Our Case Number: ABP-316119-23

Re: DART+ South West Electrified Heavy Railway Order - Hazelhatch & Celbridge Station to Heuston Station,
and Heuston Station to Glasnevin
County Dublin and County Kildare

Observation on a Strategic Infrastructure Development Application

**GLASNEVIN CEMETERY ROAD BRIDGE
(OBO10)
DECK AND PARAPET REPLACEMENT**

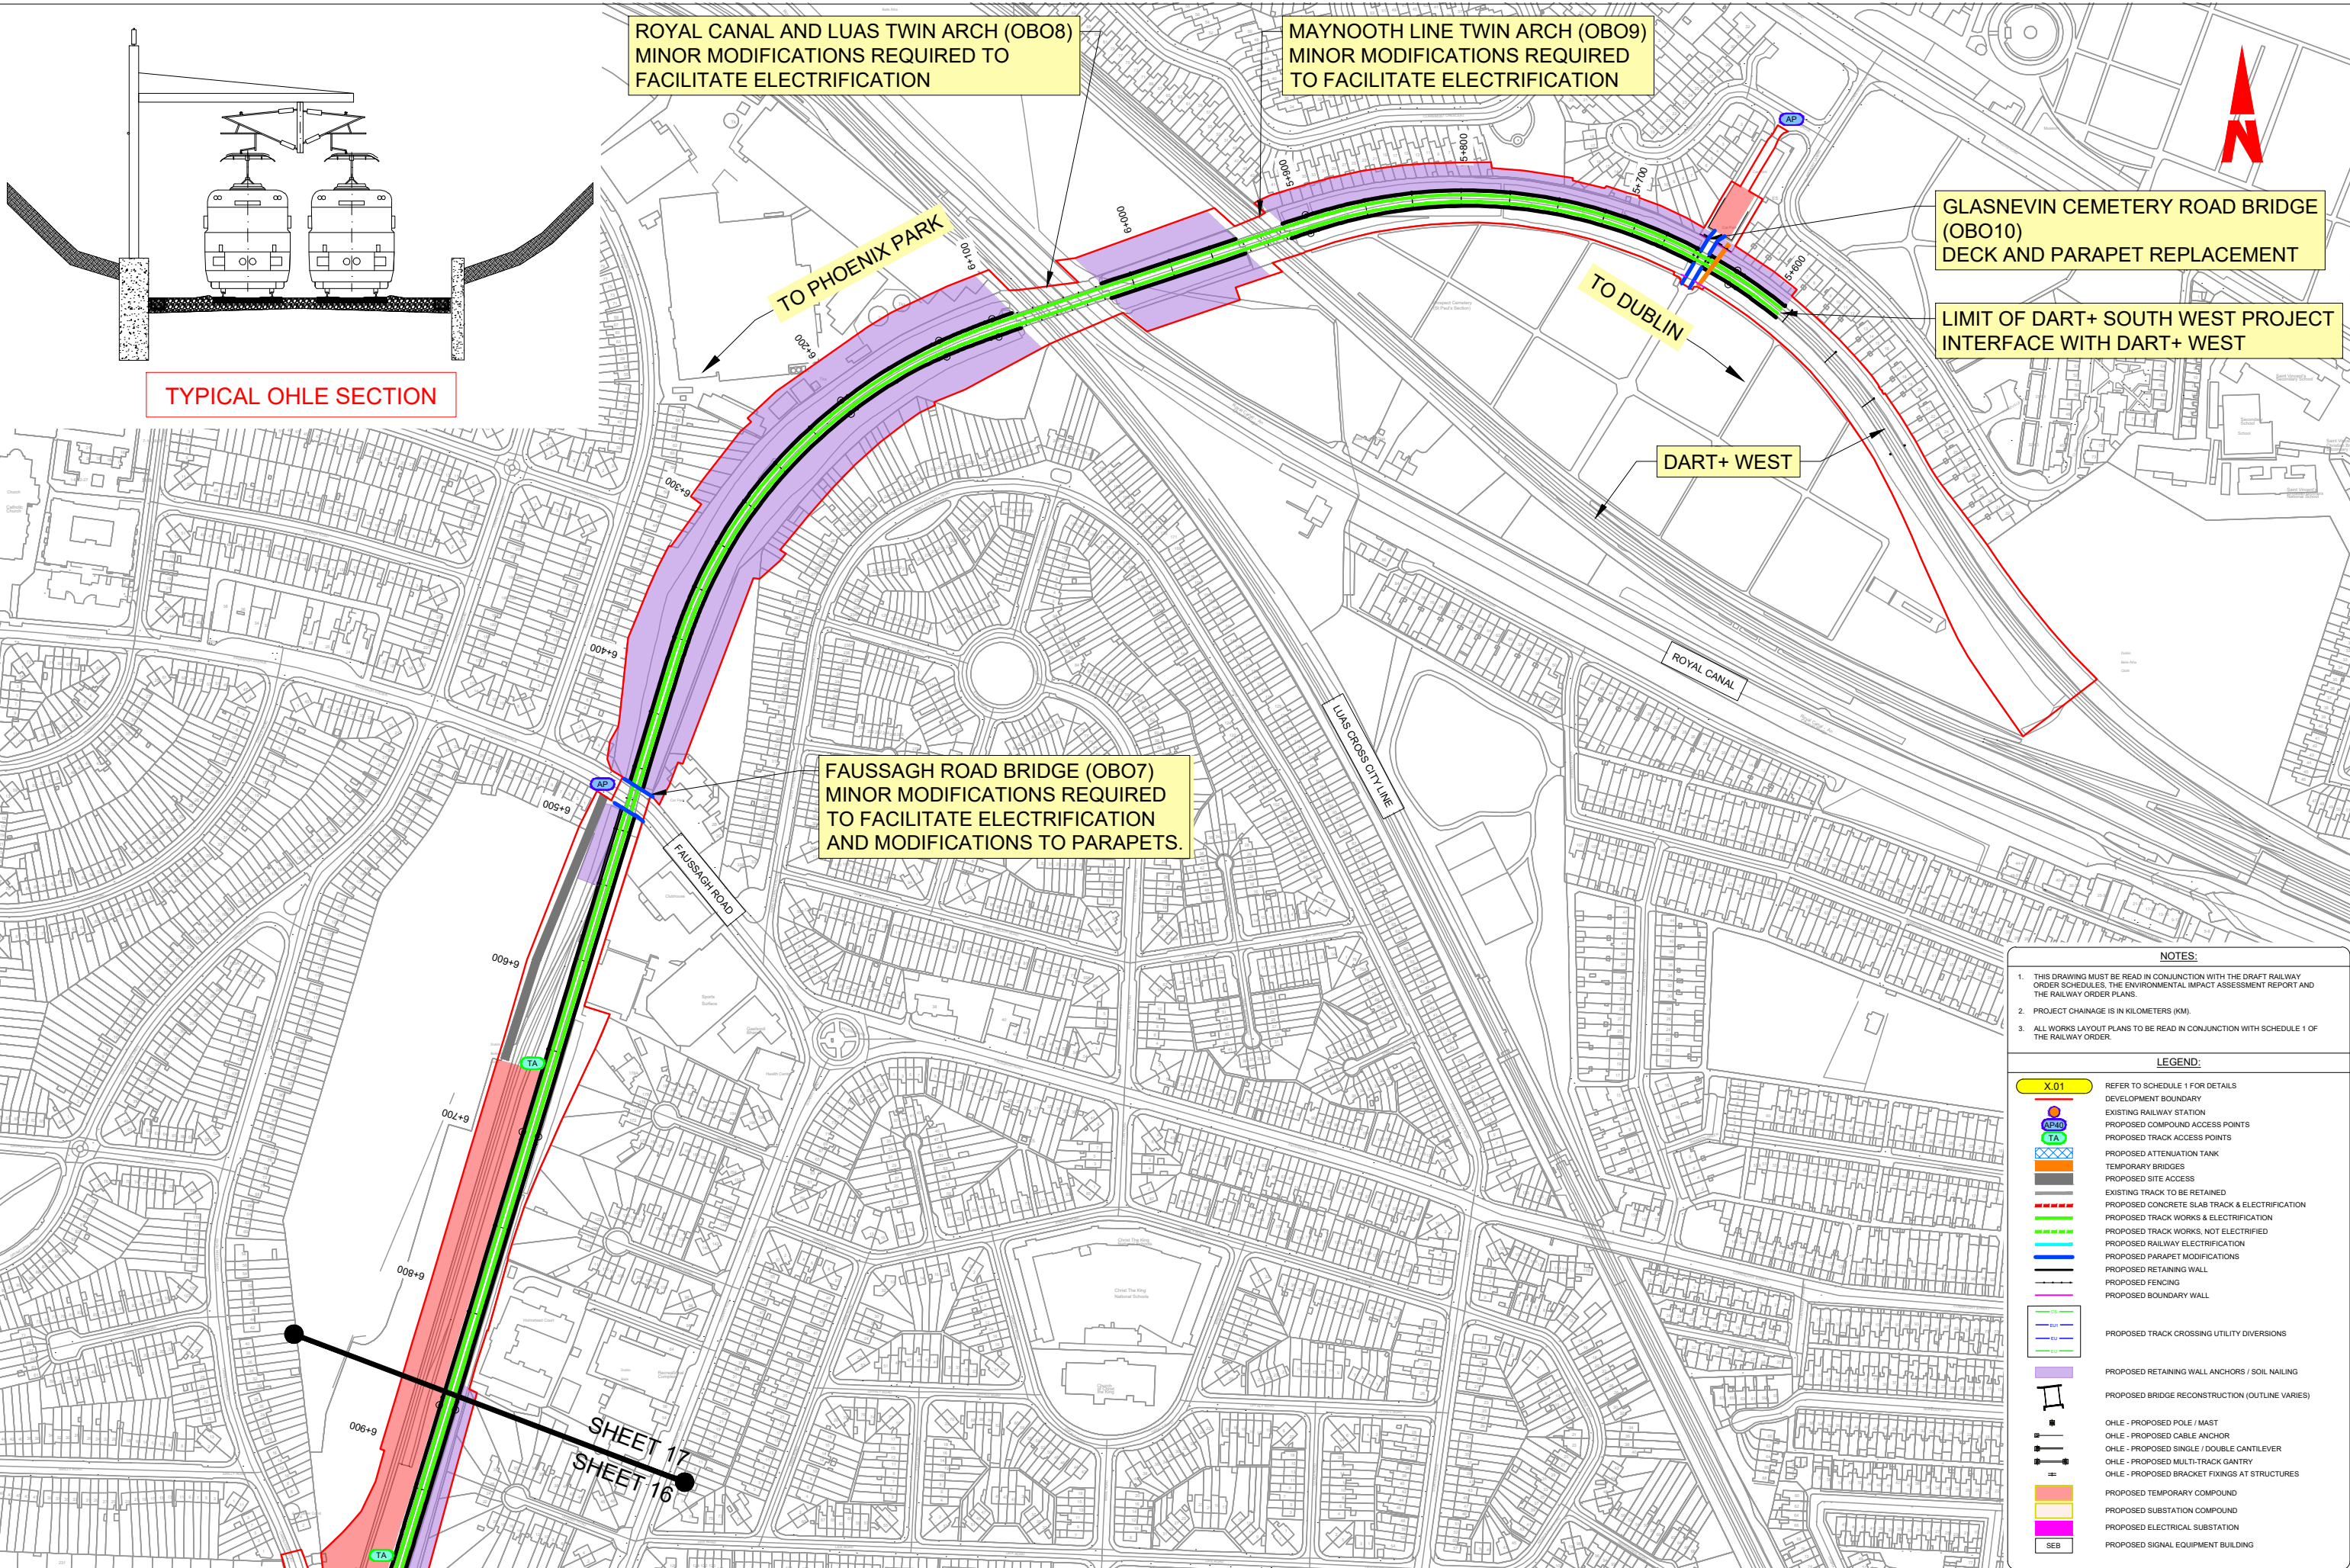
Ref: Document Server Plan Reference – 1 and Works Layout Plan No. 17 (17.12) areas identified for works compound are different and need to be agreed.

Ref: Work Layout Plan No.17 (17.10) temporary pedestrian bridge constructed. This needs to be wide enough to facilitate remains being carried by families into the cemetery. Clarification on dimensions of this bridge is needed to ensure funeral processions can have dignified unhindered access.
